24 October 2019

EPA Assessment of SSD 9505 – Regis Resources McPhillamy Gold Project Environmental Impact Statement

ATTACHMENT A: Regis Resources McPhillamy Mine EIS **EPA Comment**

Tailings storage facility – seepage management schematic

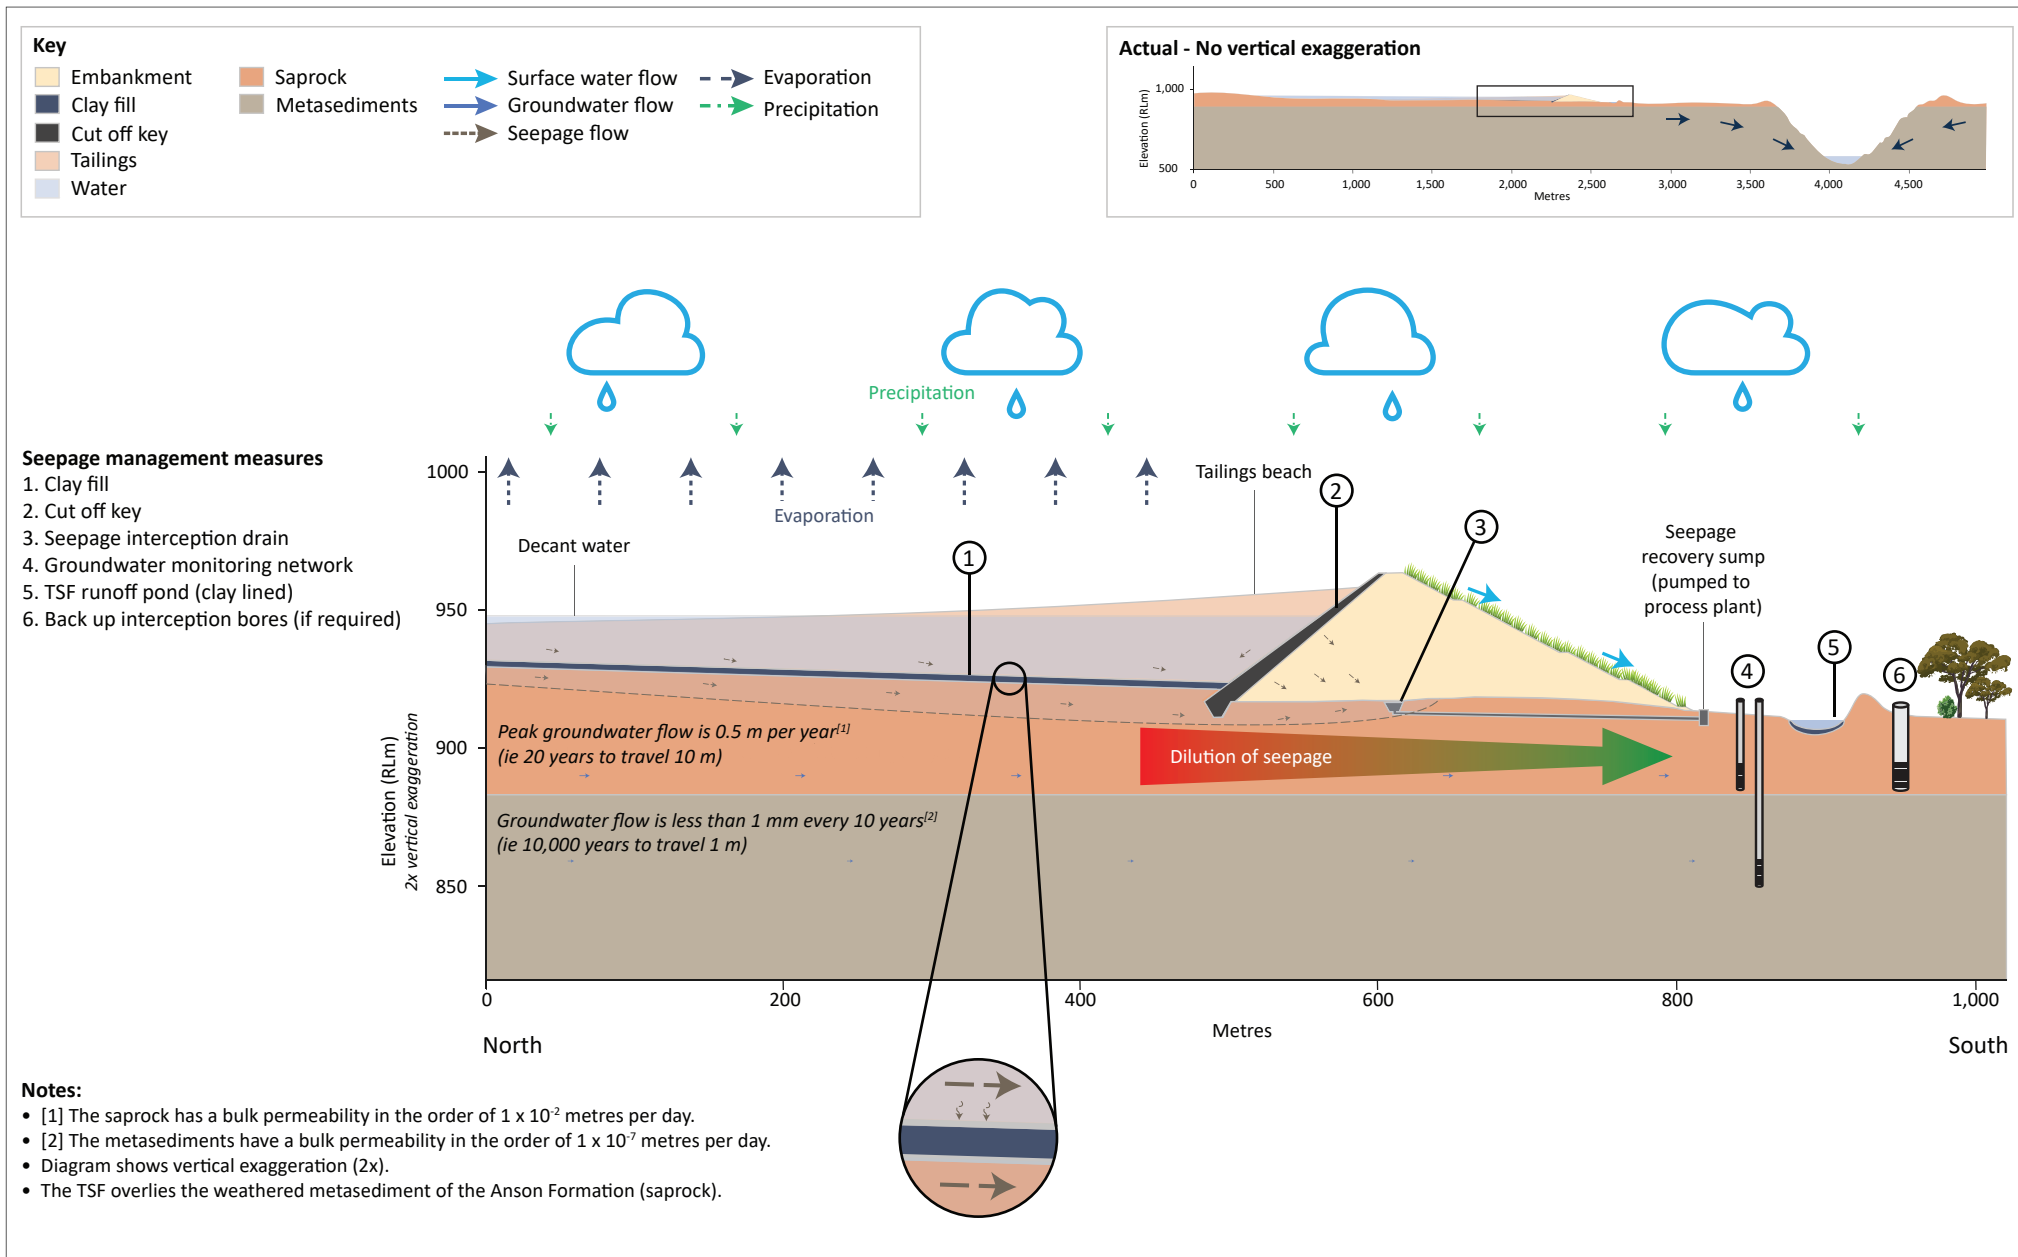
The EPA does not consider that sufficient information has been provided to allow a complete assessment of the impacts of the Proposal on ground waters. Specifically, the spatial distribution of the 3 proposed lining solutions is not provided and so there is no way to ensure that the lining systems have been adequately designed and located in consideration of the geomorphology of the area.

The proposed spatial distribution of these alternate liner methods across the TSF is not presented in the EIS. The EPA requires a minimum permeability of 1×10^{-9} m/s over a 1,000mm depth to be considered suitable to protect receiving environments as a containment barrier system (*Environmental Guidelines: Solid Waste Landfills, 2016*).

The proposal of compacting impermeable clays, where suitable, to thicknesses that are lesser than 1,000mm is not considered suitable for the preferred TSF site. The identified site of the TSF area incorporates the headwaters of the Belubula River and adjacent weathered slopes. This alternative TSF lining method of scarifying/ripping, moisture conditioning and compacting native clays across a heterogeneous weathered profile is not favoured by the EPA at this site due to the full reliance on the modelled performance of this method to mitigate the risk of seepage. The EPA believes a full depth storage blanket liner, of at least 1,000mm is required across this identified TSF site to adequately mitigate the risk of seepage. The host geology and its weathering variability increases the potential for a weakness or high permeability zone to compromise the TSF containment efficacy. For this option to be efficient all variables of risk must be mitigated, as the likelihood of a containment failure increases in relation to variables in the TSF construction. If conditioning is proposed, it should be to a recommended guideline value of a minimum thickness of 1,000mm.

Pollutants with the potential to degrade the quality of groundwater, although identified as low in the tailing assessment, must not migrate through strata over the life of the TSF. The proposed seepage recovery proposal and nominated TSF lining options as described in the EIS do not meet this requirement, nor do they consider contingency management actions in the event that seepage rates exceed those produced by the assessment modelling. Post closure monitoring, management and recovery of seepage is also not considered in sufficient detail to allow an assessment to be made.

More detail regarding the TSF design, dam construction, operation and post closure seepage management activities is required to assess the suitability of the proposed design at the preferred TSF site. The EPA maintains a preference for an engineered impervious seal of at least 1,000mm with a minimum permeability of 1×10^{-9} m/s preventing contained leachate material migrating to underlying strata.
